Application No: BE/36/21/HH
Site Address: 32 Norbren Avenue Bersted PO21 5HE
Description of works: Two storey rear extension, first floor side extension and conversion of roof from hip to gable end.

Thank you for your internet representation made on 31st March 2021 which has been recorded as an objection with the comments as follows:

REVISIONS REV A 03.03.2021 Alterations to new east boundary wall, rear extension, and west 1st fl extension	
PROJECT 32 Norbren Avenue Bognor Regis PO21 5HE	
DRAWING Proposed Elevations	
SCALE 1:100 • A3	DATE July 19
DWG.NO. 1903-01-04	REV. A

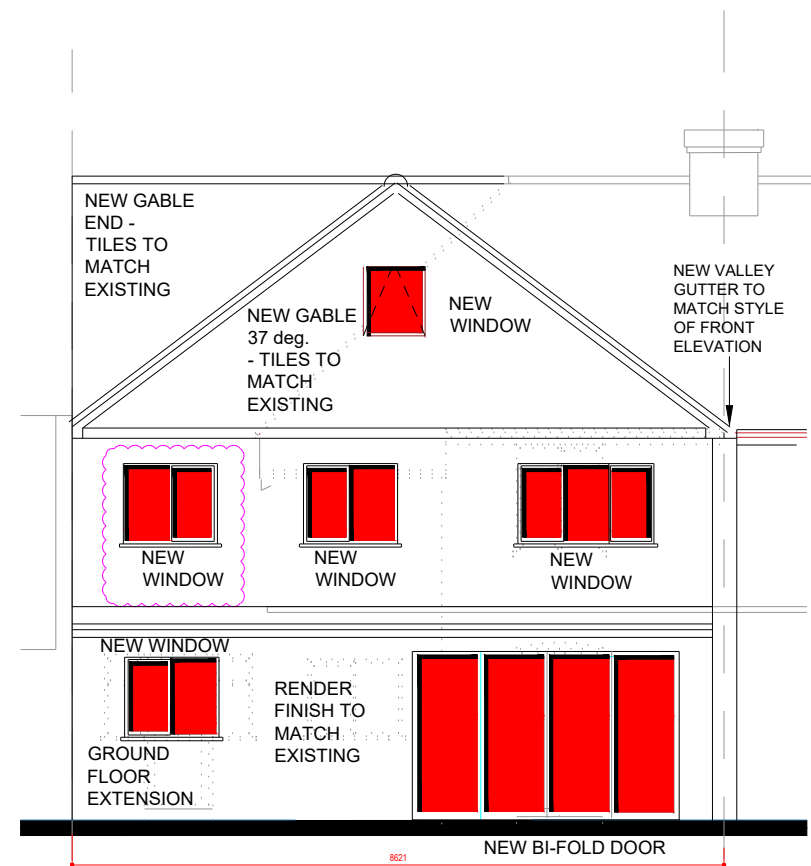
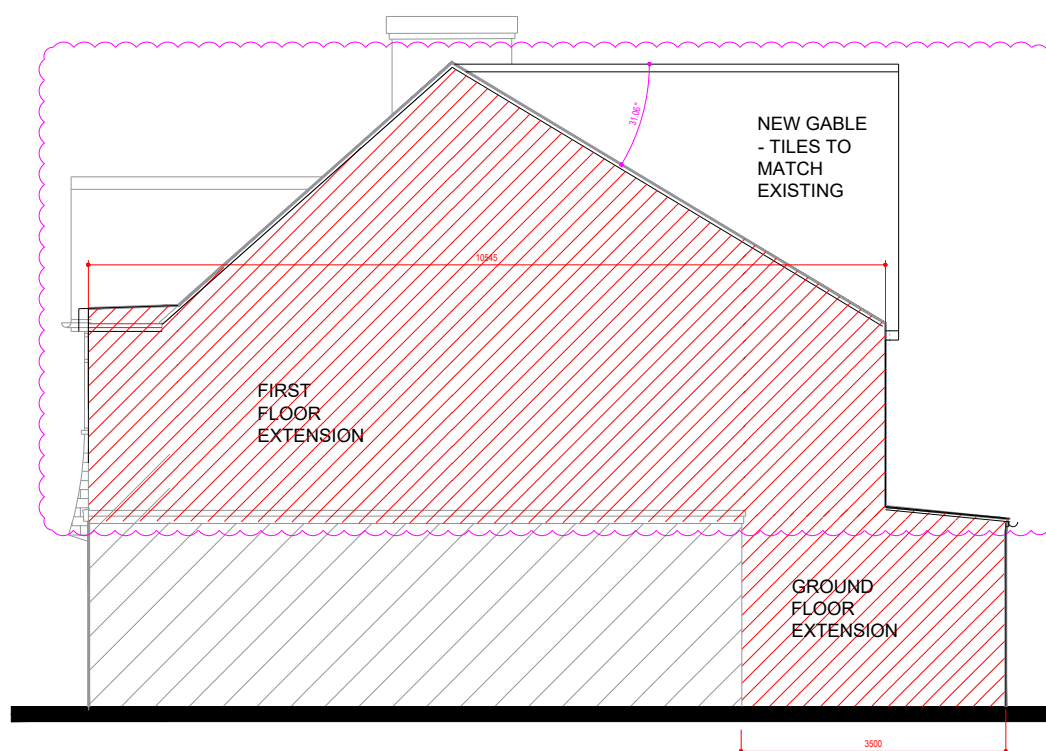
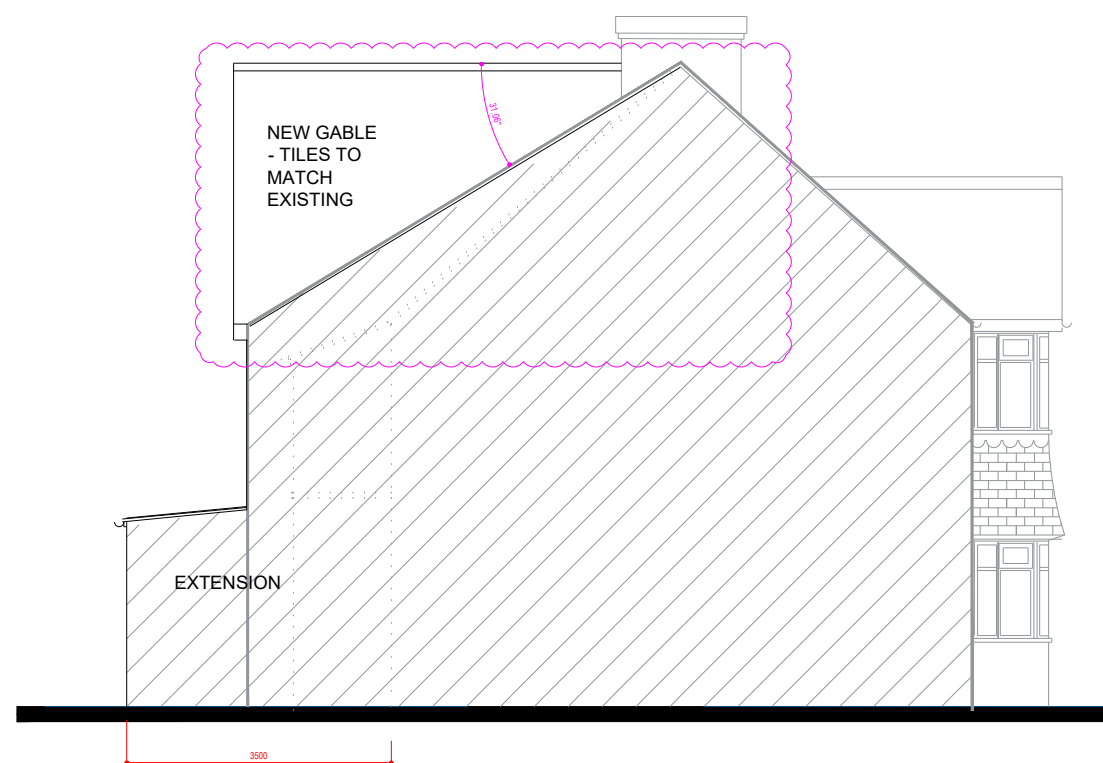
The proposed first floor extension at the rear of the property protrudes beyond the back building line of the original semi-detached house, i.e. the bathroom/kitchen on the original building. I am concerned about the loss of daylight to the rear bedroom, dining room and conservatory of my property, 30 Norbren Avenue. This would be amplified during winter months.

I feel strongly that the size and majesty of this proposed extension is not in keeping with the surrounding properties. Also, the window in the converted loft space would encroach on ours and neighbours privacy in their back gardens.

However, I would be willing to withdraw my objection to the planning application if the extent of the rear 1st floor extension did not go beyond the building line of the kitchen/bathroom rear wall, i.e. 1.2m from the main building structure not 1.9m as shown on the plans. This would not have such a detrimental effect regarding the light to the rear of my property.

1. During construction all measures must be taken to prevent any damage to our conservatory.
2. The wall which would overlook our conservatory should be rendered and painted white as this will alleviate the problem of loss of light to our bedroom, conservatory and dining room.

3. Finally, this may be something I would have to come to an arrangement with my next door neighbour, the construction of a snow guard along the gutter which would overhang our conservatory. This is to prevent any loose tiles from the sloping roof slipping down and crashing into the roof of our conservatory.

GROUND FLOOR - EXISTING

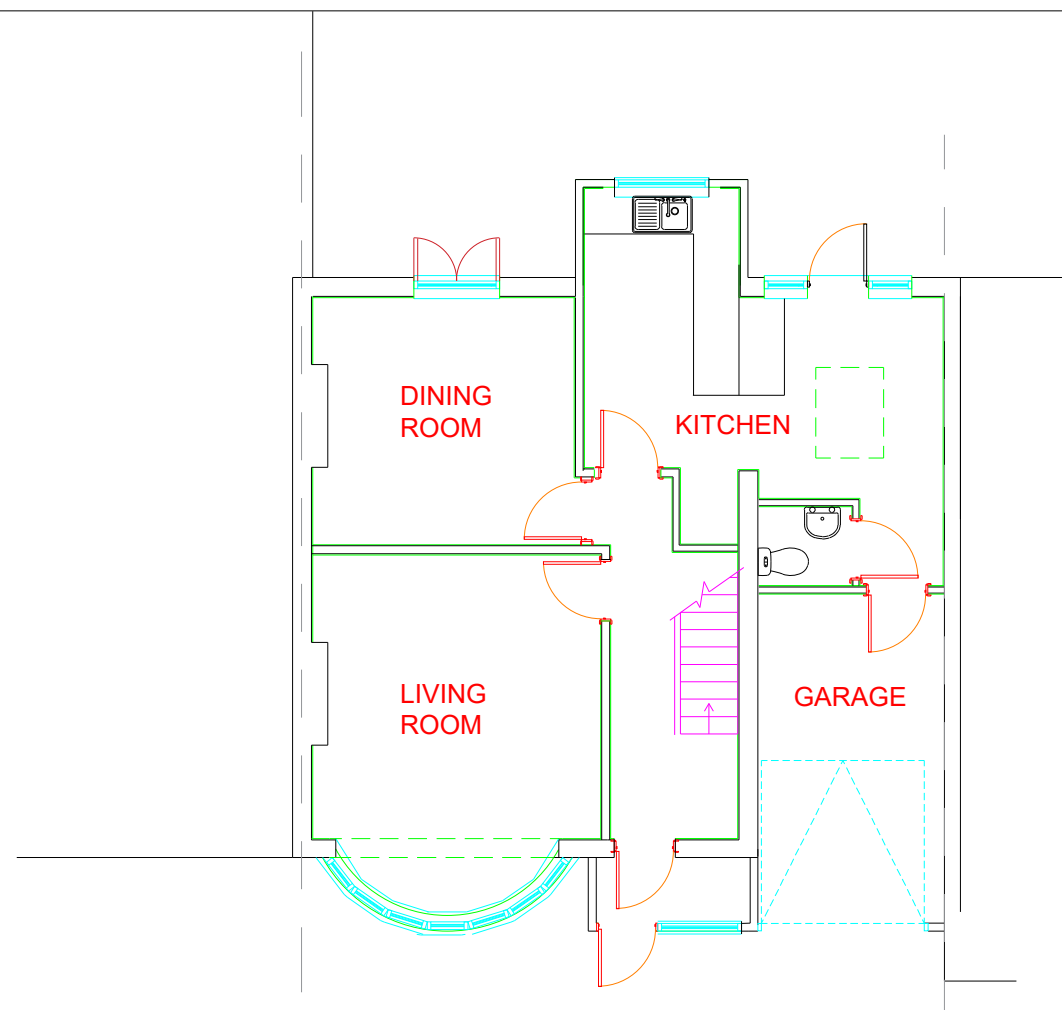
I am concerned about the accuracy of the plans as they show chimney breasts in the living room and dining room. We believe all the chimney breasts were removed from the property 12-18 months ago. The chimney stack is being supported by cantilevers from the partition wall in the loft area. Therefore with this large loft extension work I would need assurance that the structure of the semi-detached building is sound. No doubt this will be taken into account under the Building Regulations.
